Rezoning Transportation Analysis

Petition Number: 2025-104

Date	Description
9-24-25	First Review (CM)

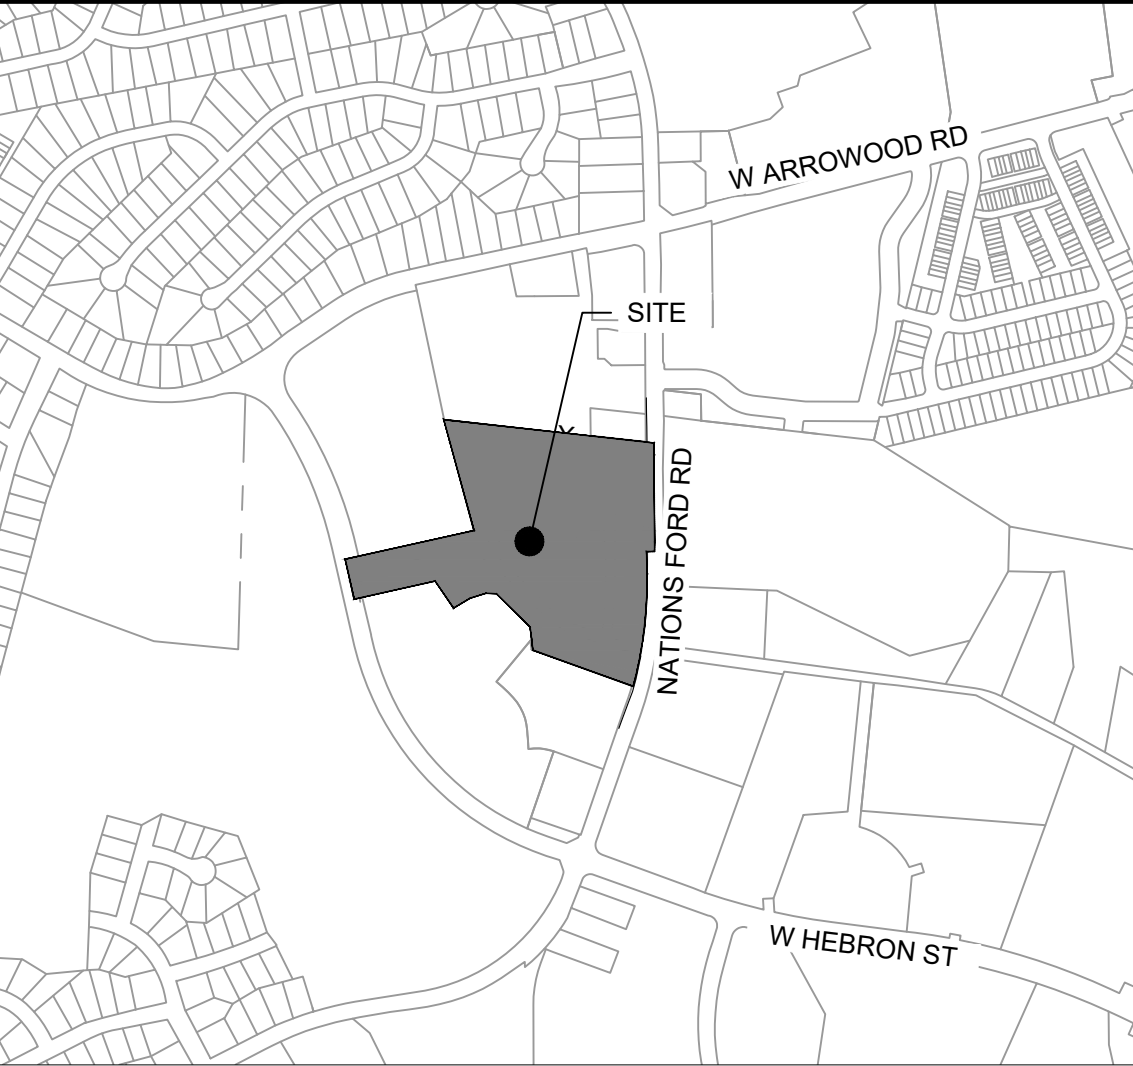
Label and dimension the curb and gutter from the centerline for each road on the site plan.

3. Revise site plan and conditional note(s) to commit to dedicate 43' of right-of-way from the road centerline along West Hebron Street and Nations Ford Road and 33.5' along Old Hebron Road. The site plan shall label and dimension the right-of-way from the road centerline.

4. Revise site plan and conditional note(s) to commit to construct bicycle facilities by locating the curb and gutter 27' from the center line along Nations Ford Road in accordance with the council-adopted Charlotte Streets Map. Site plan to callout and dimension bicycle infrastructure and add a conditional note to committing to this improvement.

5. Revise site plan and conditional note(s) to show bike facilities along Nations Ford Road with labels and dimensions.
6. Revise site plan and conditional note(s) to label Road A, B, and C as public roads, private roads, or private alleys. Add road labels for all roads to site plan. Add conditional note(s) identifying each roadway.

7. Revise site plan to show Road A has adequate intersection separation from Nations Ford Road per CLDSM guidelines.
8. Revise site plan to adjust stub location of Road A to the west to stub into the larger western parcel in coordination with Subdivision.

9. Revise site plan and conditional note(s) to provide a streets stub and right-of-way in accordance with the original Old Hebron Road alignment per Charlotte Streetsmap. The alignment of the proposed Old Hebron Road may need to be modified to accommodate the roadway stub and the original alignment. Final design to be coordinated with CDOT during permitting. Add a conditional note committing to this improvement.
